**Case Reference:**  
**ABP-308291-20**

### **Notice of Pre-Application Consultation Opinion**

**Proposed Development: 564 no. residential units (96 no. houses, 468 no. apartments), childcare facility and associated site works.**

**Former Bray Golf Club Lands, Off Ravenswell Road and Dublin Road, Bray, Co. Wicklow and Co. Dublin.**

Purpose	PLANNING
Title	VEHICLE TRACKING ORCHARD EXISTING UNDERGROUND IRISH WATER FOUL STORAGE TANK
Original Scale	1:250 at A1 1:500 at A3
Design/Drawn	AK
Checked	CF
Authorised	KB
Date	19.08.22
Date	19.08.22
Date	19.08.22
Status	P
Drawing Number	5214419-ATK-01-ZZ-DR-CE-0126
Rev	P01

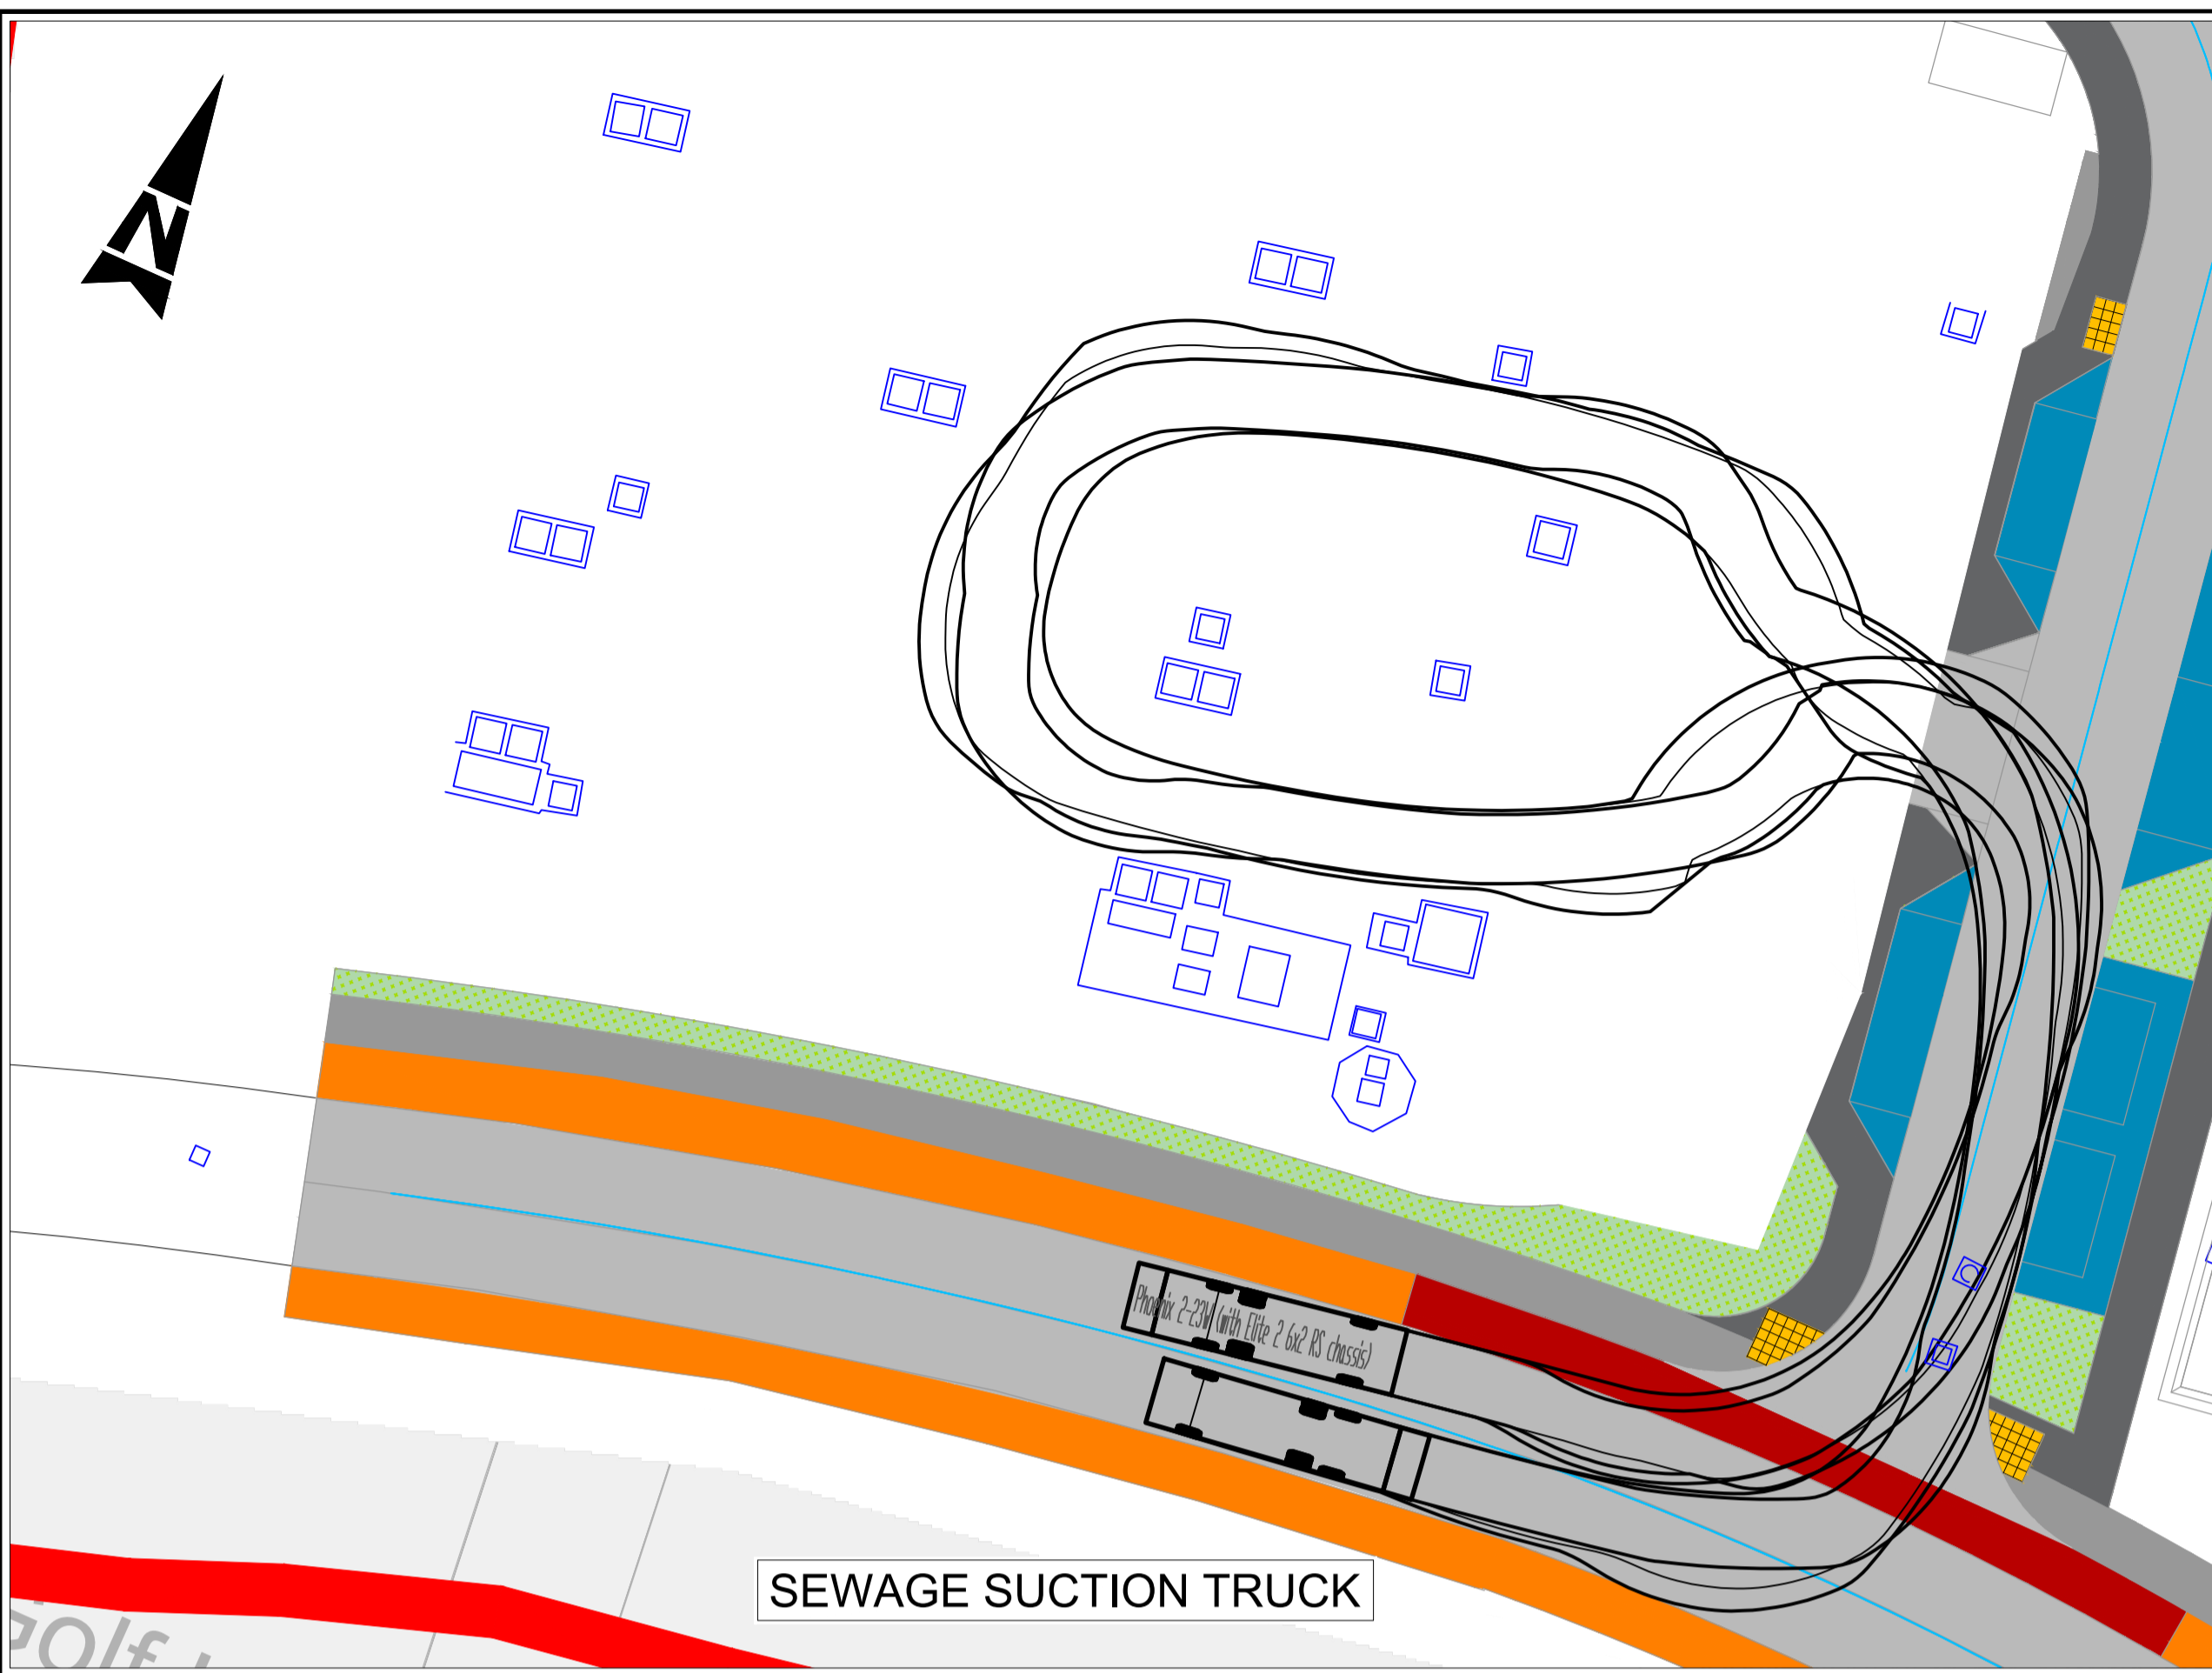
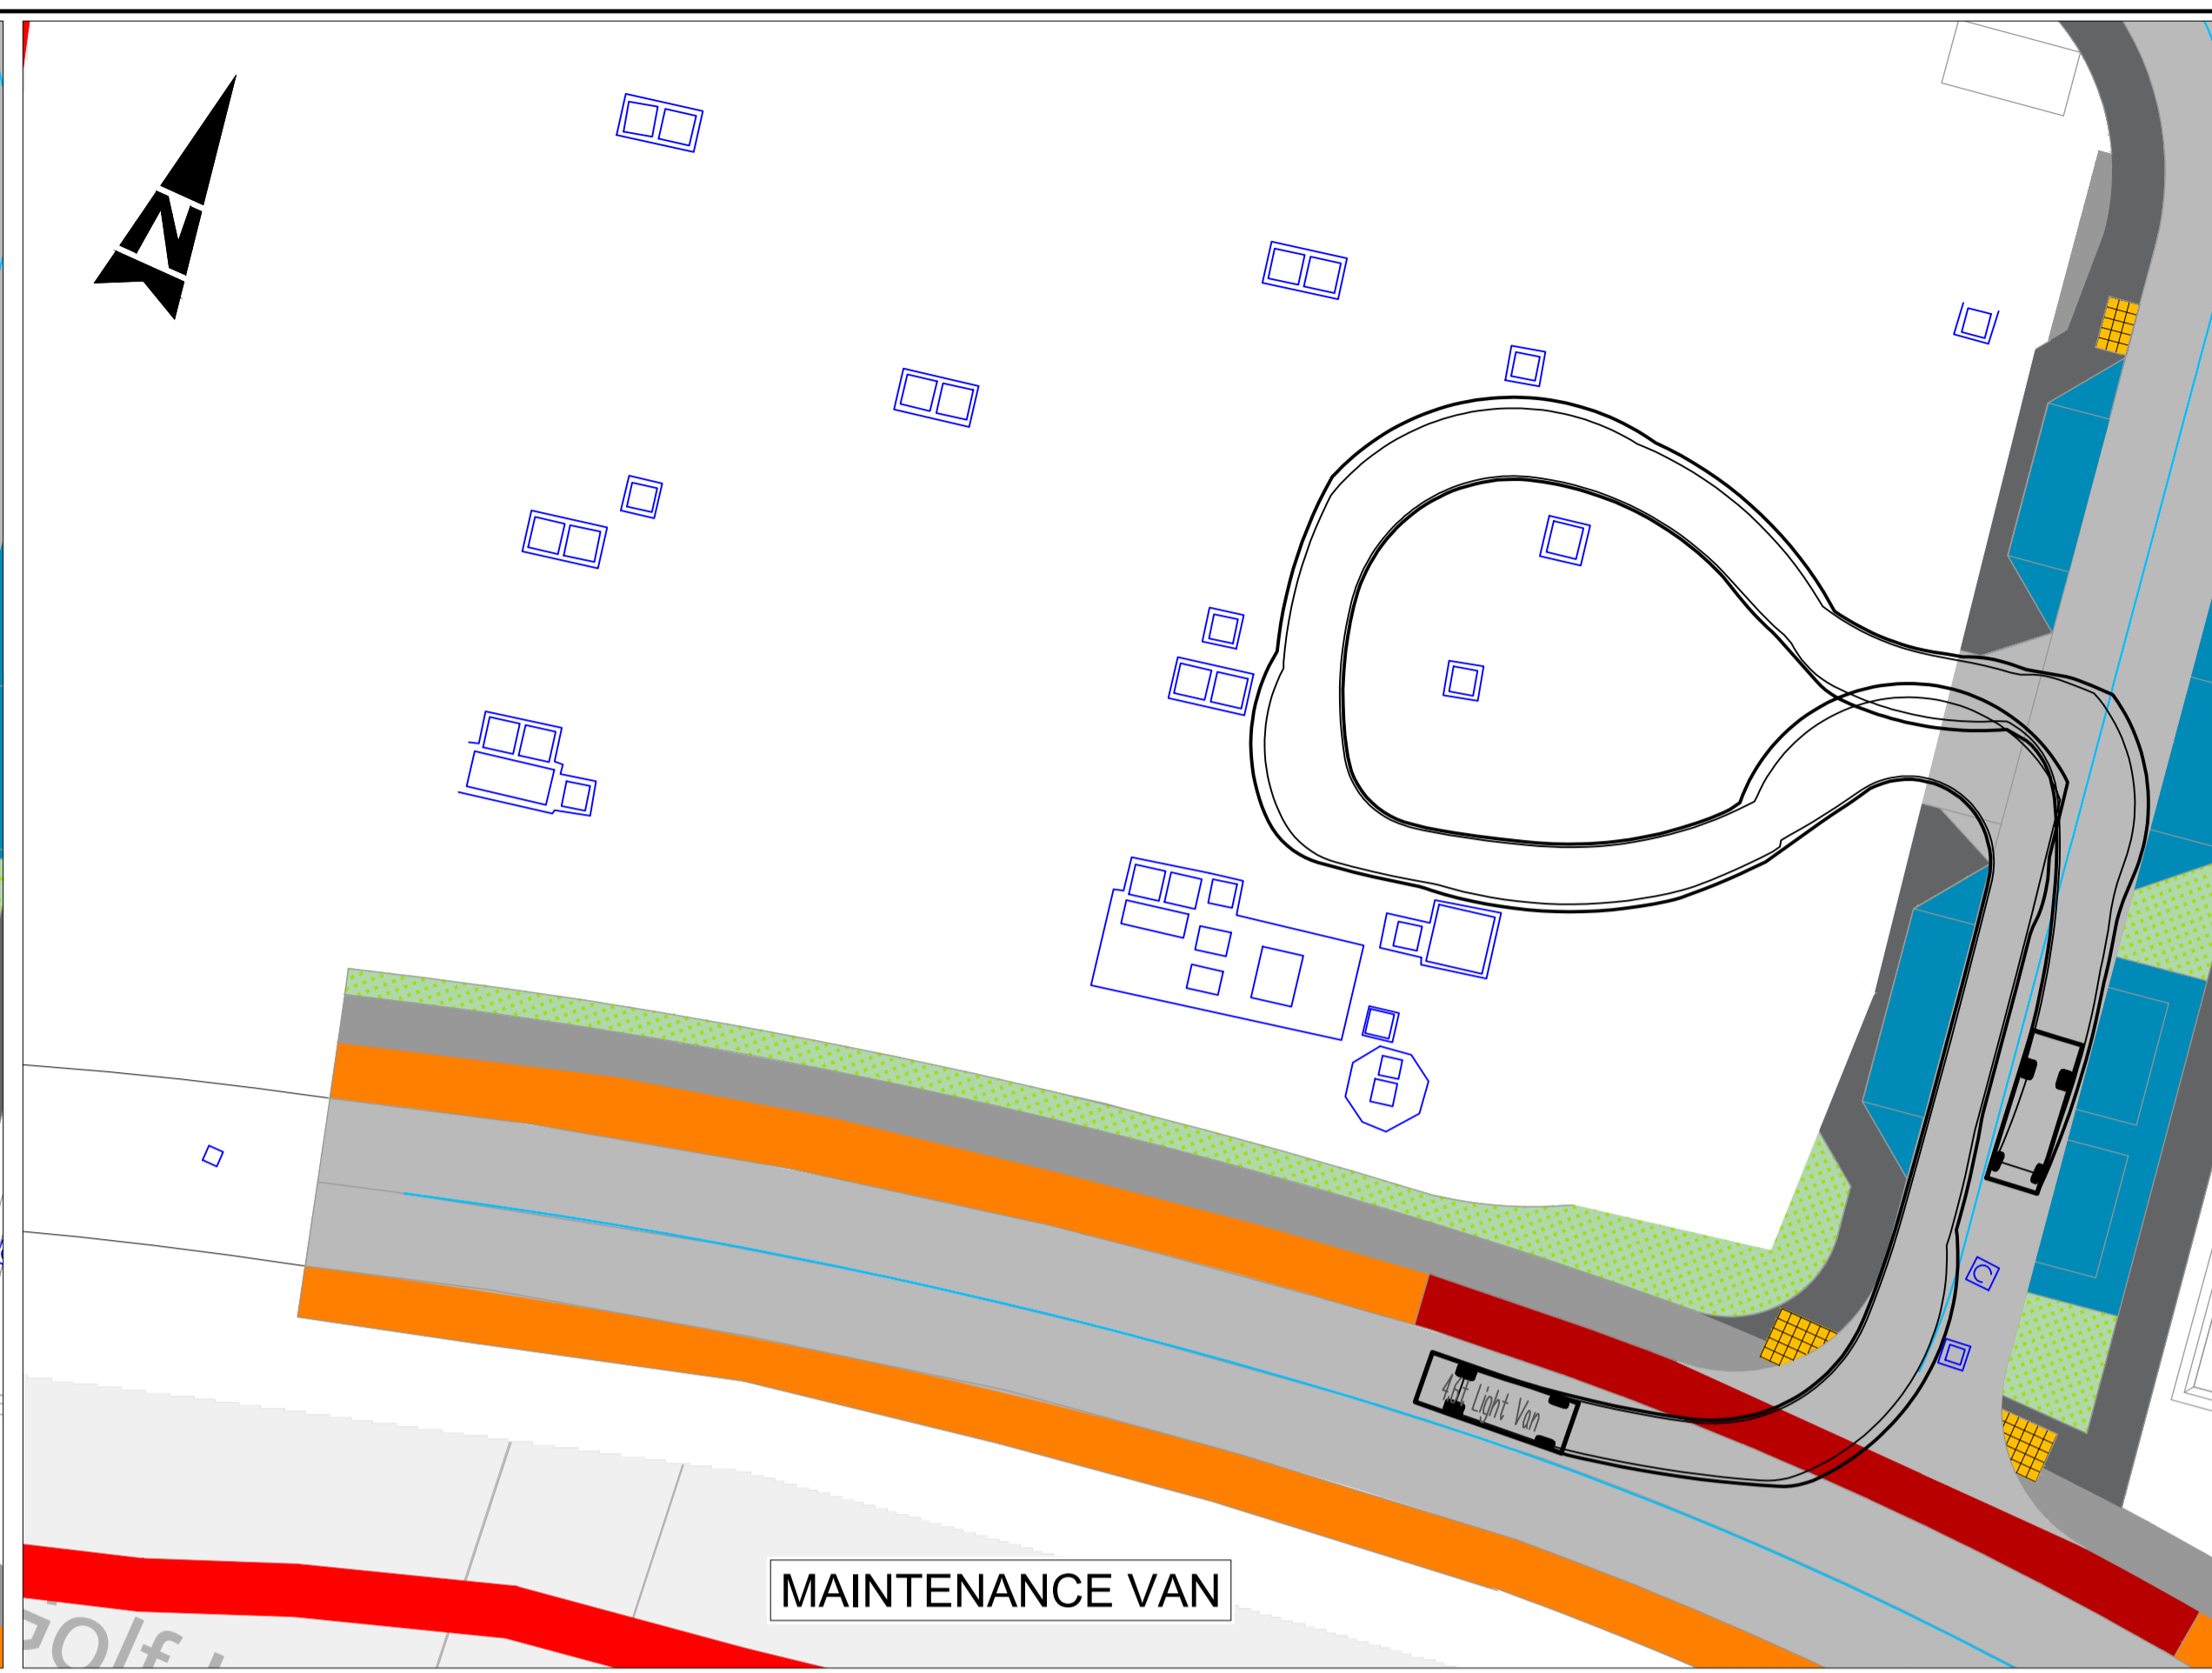
4. Further consideration of the relocation of Irish Water infrastructure located underneath 'The Orchard' in the south west portion of the site having regard to its potential negative impact on the development potential of the site and the public realm. In the event that the infrastructure is not to be relocated then a justification should be submitted at application stage that seeks to address, *inter alia*, the potential negative impact on the development potential of the site and the public realm at this location.
